Addendum No. 1

RE: Contract # C204770 WBS # 67094.3.1 STATE FUNDED **Rockingham County (BR-0094)** BRIDGE #69 OVER US-220 ON US-770.

January 17, 2023 Letting

REVISIONS SHEET NO. S-04 NO. BY: DATE: DOCUMENT NOT CONSIDERED FINAL UNLESS ALL TOTAL SHEETS SIGNATURES COMPLETED 30

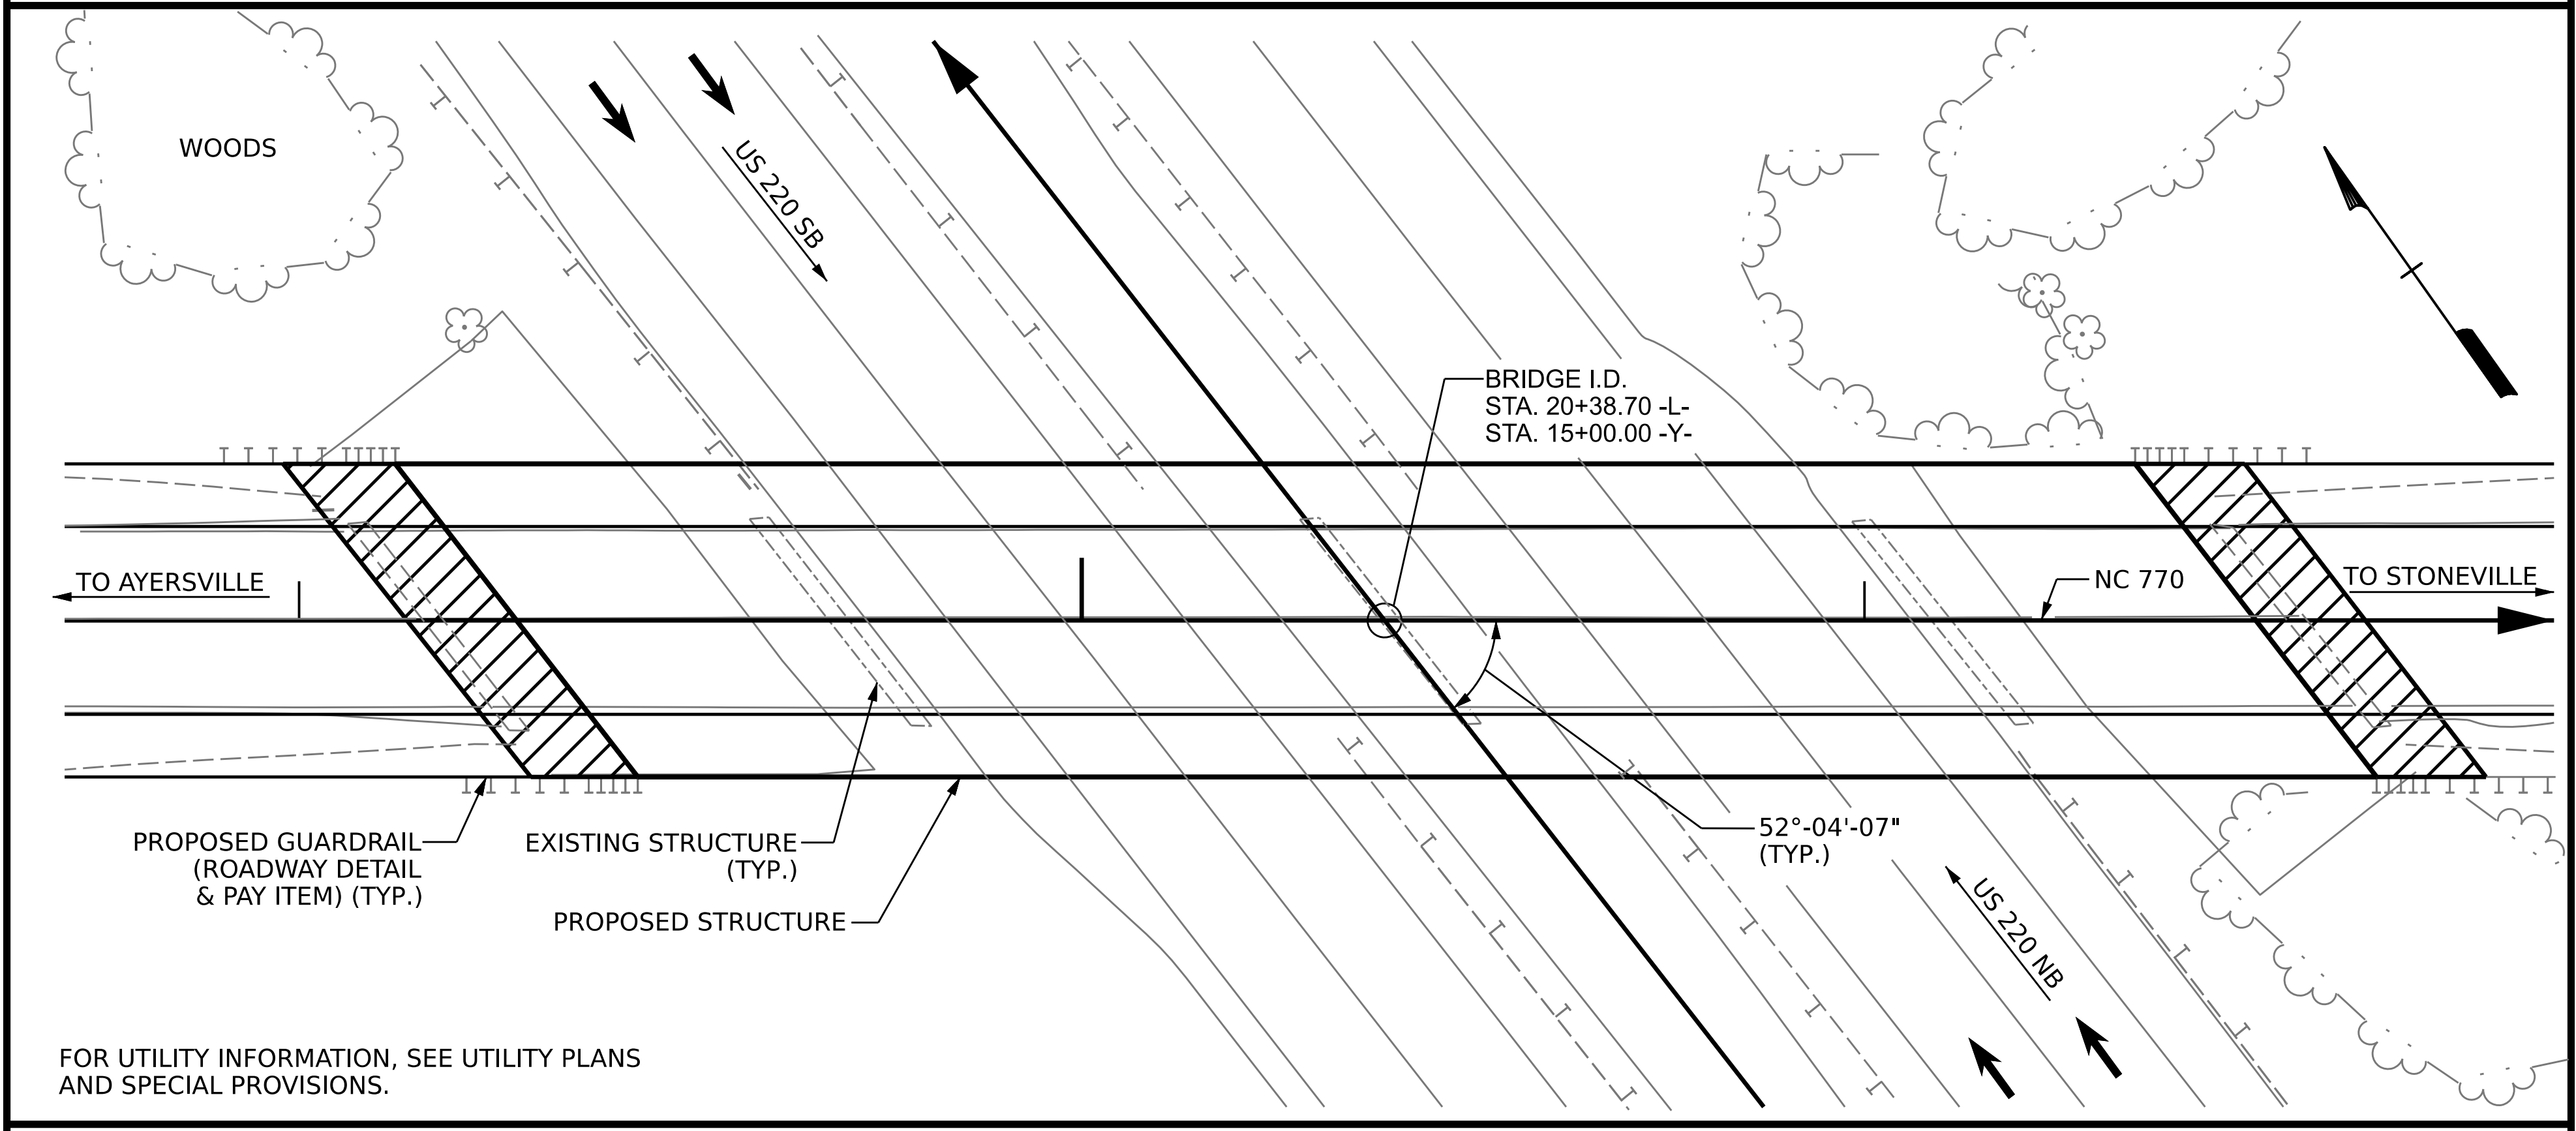
Sheet No.	Revision
S-04	Bill of Material updated to reflect quantity change below.

<u>Item</u>	<b>Description</b>	<b>Old Quantity</b>	New Quantity
0113-818200000-E- 420	CLASS A CONCRETE (BRIDGE)	480.5 CY	189.6 CY
